Householder Proforma

Application Ref: 2021/1292
Address: 531 Doncaster Road, Ardsley, Barnsley, S71 5EN
Property Description: the stone built detached dwelling is located within a predominantly residential area on the periphery of Ardsley along the main highway linking Ardsley and Darfield. The dwelling backs onto open fields to the south.

Proposed Extension: Erection of single storey rear extension with first floor balcony above.

Project No. MBP001	Drawing No. 003	Revision -
------------------------------	---------------------------	----------------------

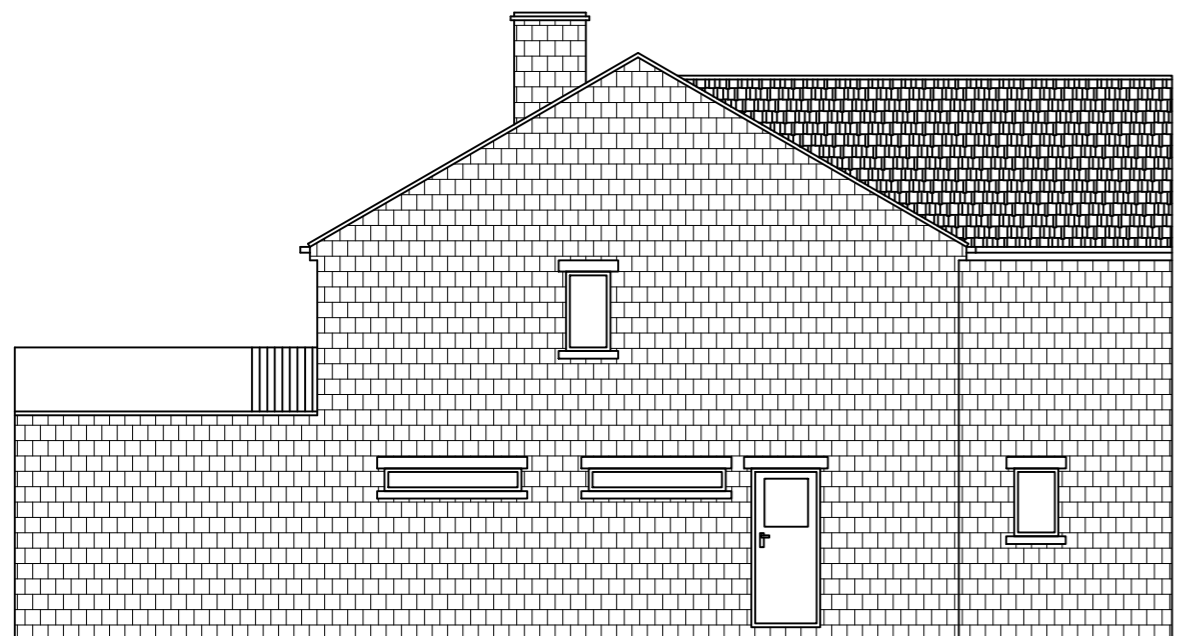
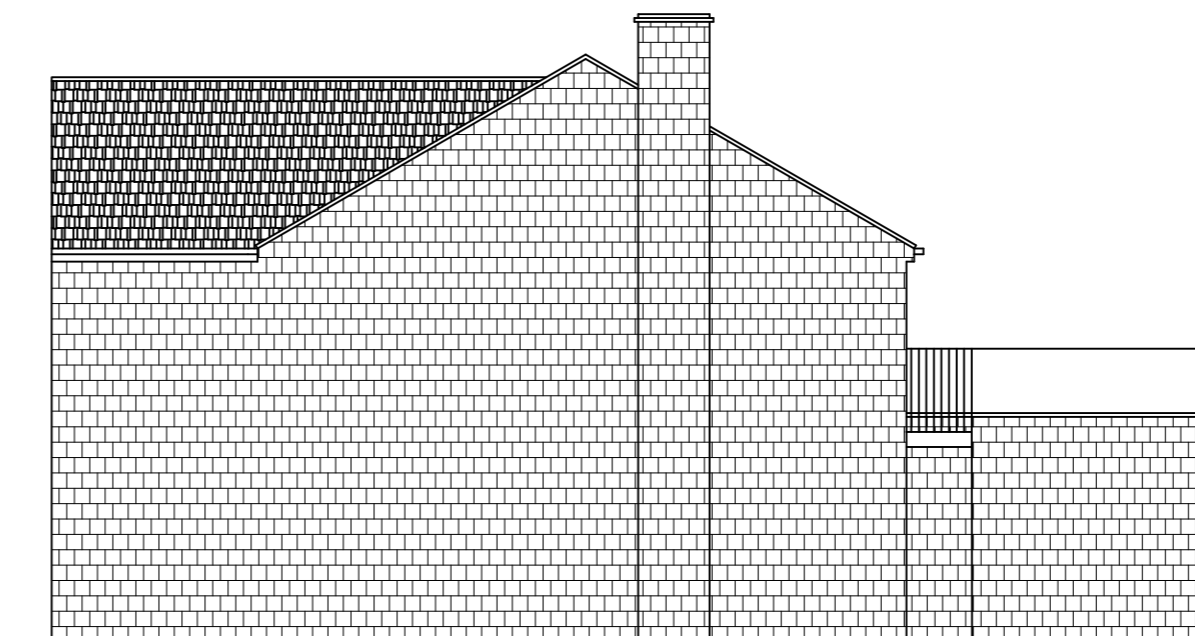
The extension is to project 4m from the rear elevation, extending 8m along it and have a height to the top of the vertical wall of 2.95m, within the parameters of permitted development. However, as the extension proposes to utilise the roof as a balcony, planning permission is required.

The proposed extension is to be located on the rear elevation of the dwelling and constructed of stone to match the existing dwelling with a glass balustrade and as such is considered acceptable in terms of visual amenity in compliance with Local Plan Policy D1

Project No. MBP001	Drawing No. 003	Revision A
------------------------------	---------------------------	----------------------

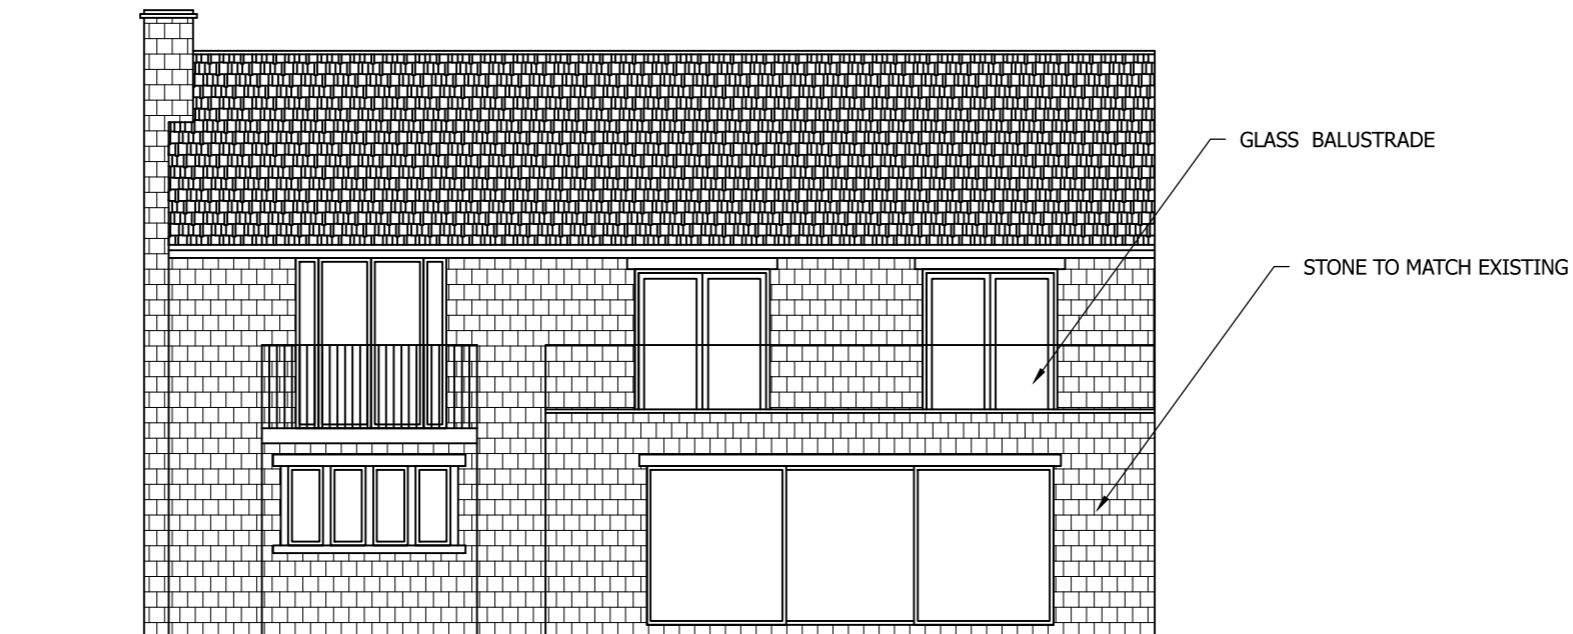
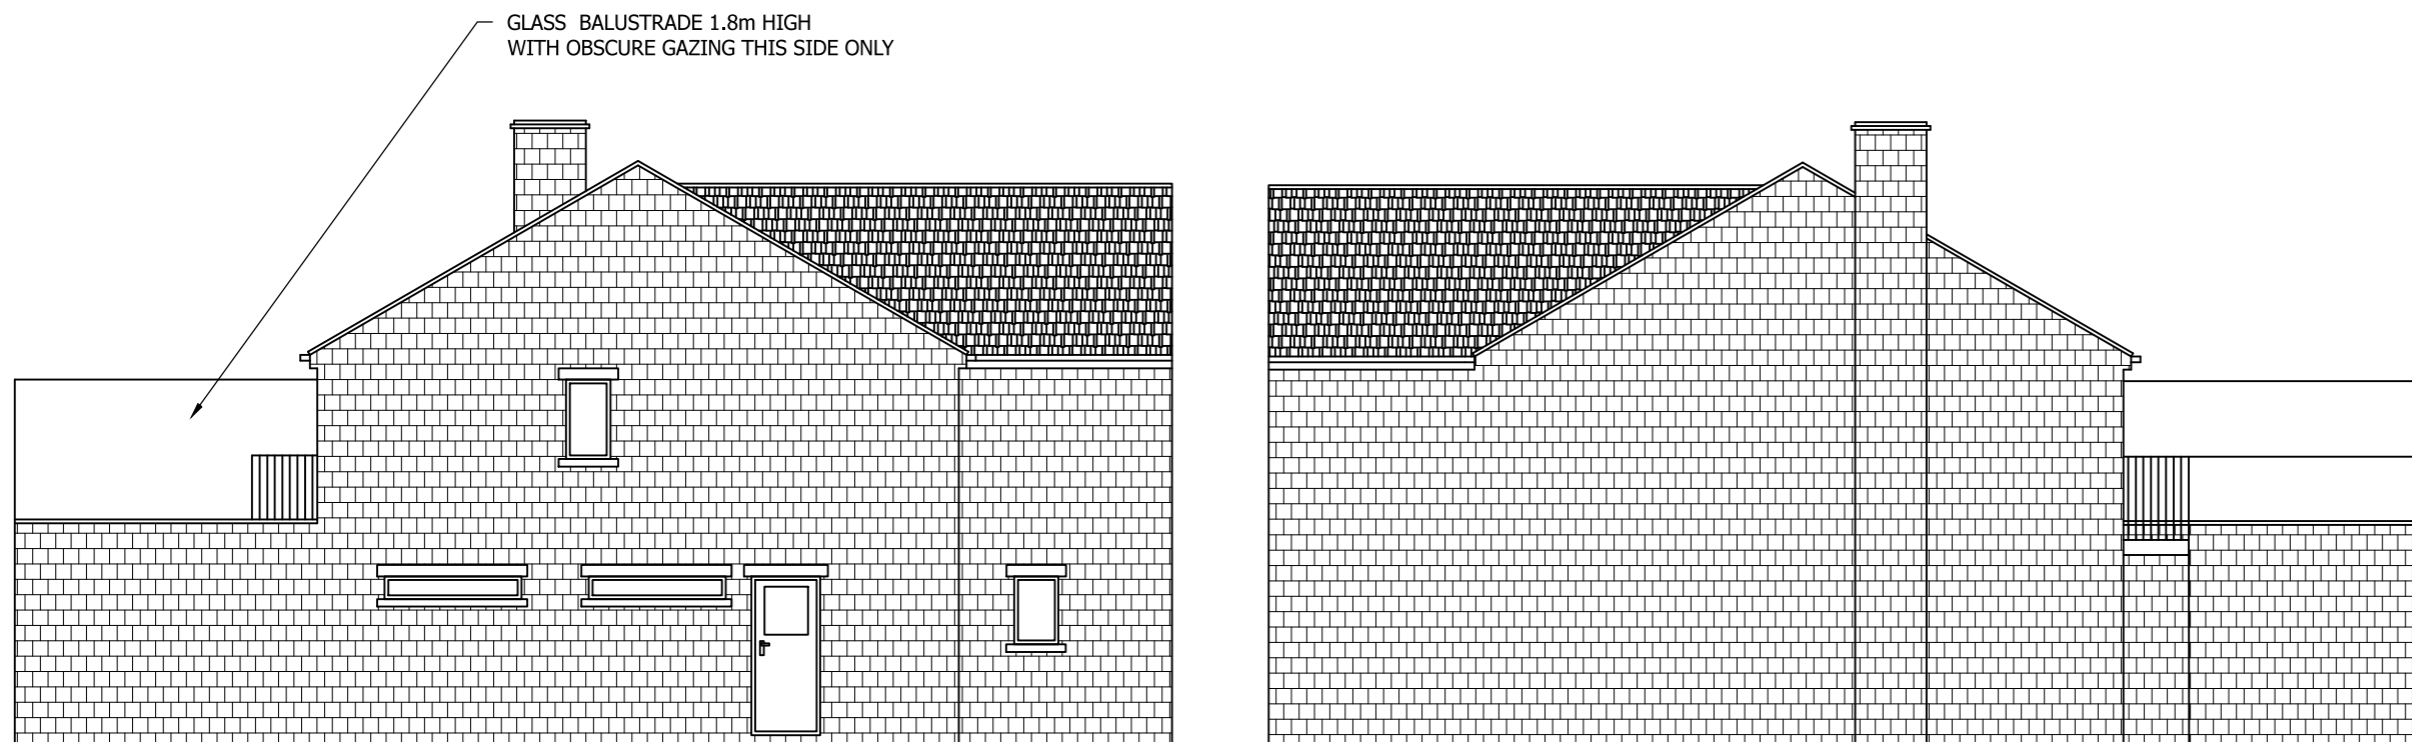
The inclusion of the 1.8m obscurely glazed screen to the eastern elevation of the balcony would provide adequate screening of the neighbouring property in addition to it being set further back into its site, resulting in 2.2m of the proposed extension projecting beyond the rear elevation of the potentially affected dwelling.
